The Planning Inspectorate  
M23 junction 10 / A3 Wisley Interchange

I am the County Commissioner for Girlguiding Greater London West and we own Heyswood Campsite which is being affected by the M25 junction 10 / A3 Wisley Interchange Improvement Plan.

Our Response to the DCO

Millimetres  
0 10 100

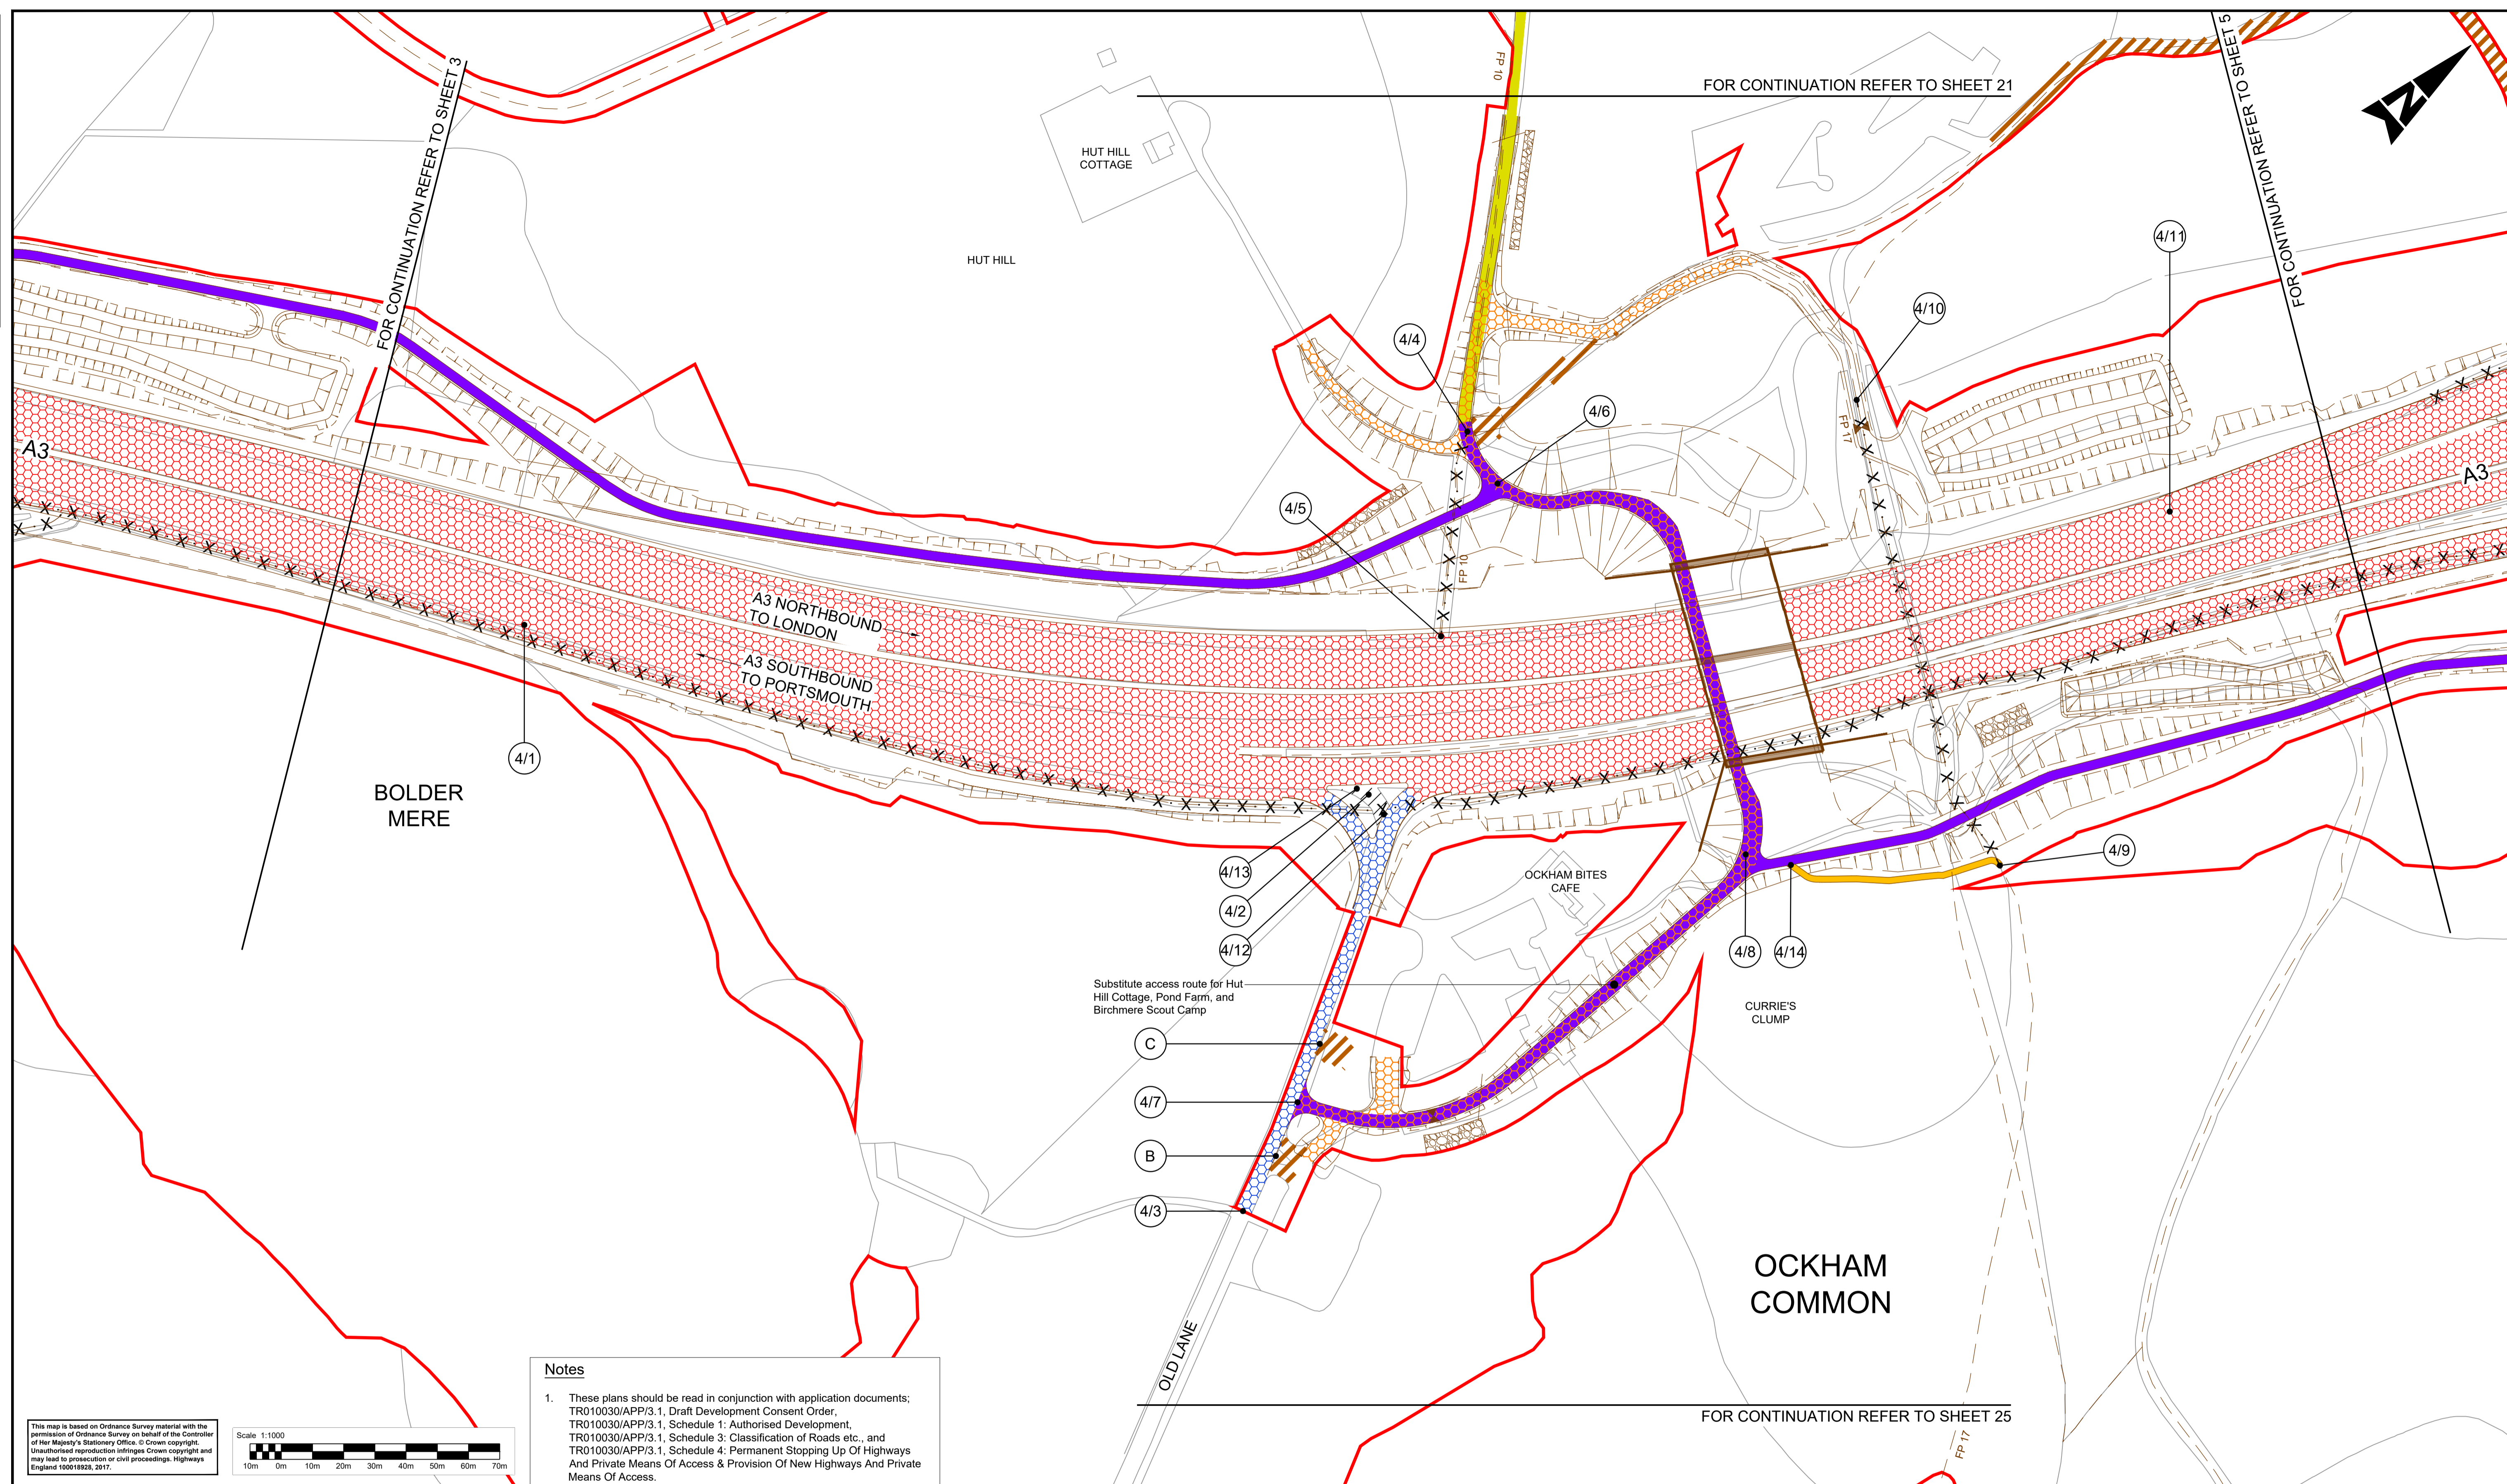
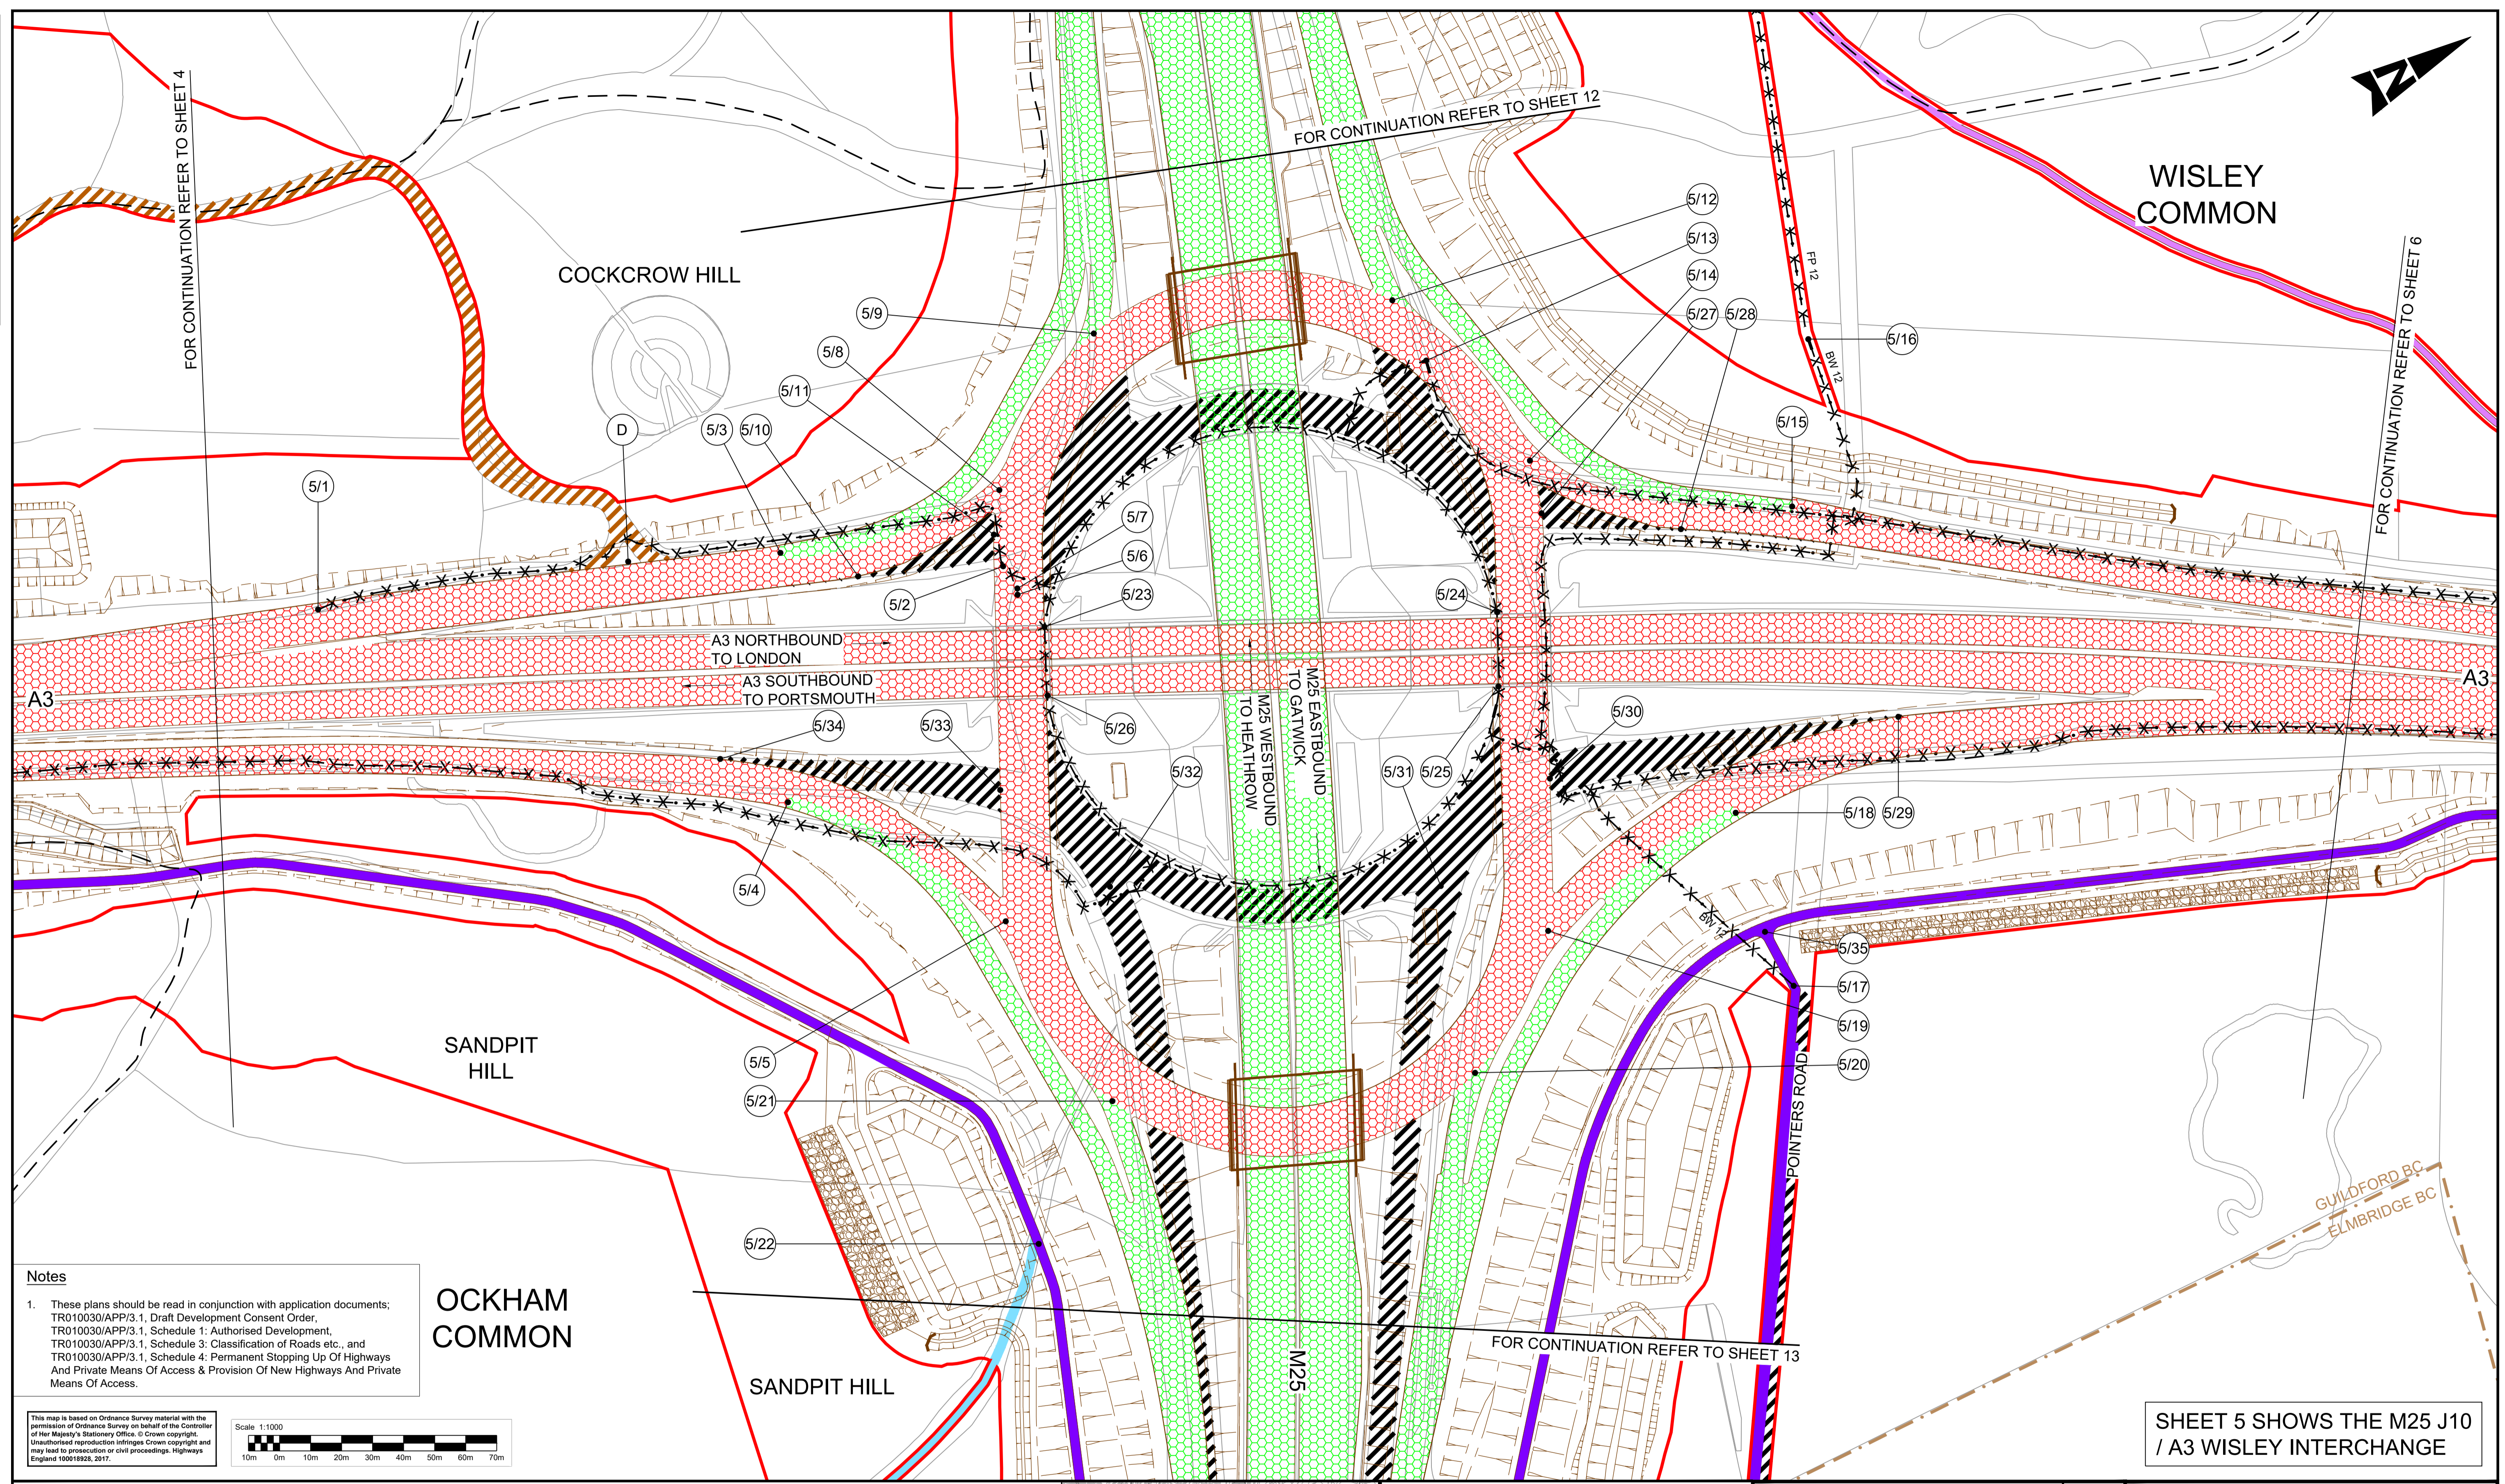
- The map showing the new road proposal across our land is inaccurate. It is inaccurate in that the current track is inaccurately marked. This makes it difficult to be sure where the new road is proposed.

- The map also shows, fencing on both sides of this road, yet when we queried this with Highways England and Atkins, they indicated that they had not intended this to be the case so they were not sure why this is showing.

- We have asked for the width of the track to both be minimised and as close to the current track as possible to ensure that trees are not felled unnecessarily. Currently the mature sweet chestnut that is of regional significance is showing as being felled as it is within the new road proposal.

- We have asked for the security gates at the east end of the site to be moved to the boundary as we will continue to need to access buildings alongside our eastern boundary.

- There are a number of symbols on the maps that are not included in the legend and we have asked Atkins/HE for clarification e.g. triangle with CO2, blue circles.

- We have two cess pits on our site near the A3, which service all the buildings on site, and it is still unclear whether these are within the land affected by the DCO or not.
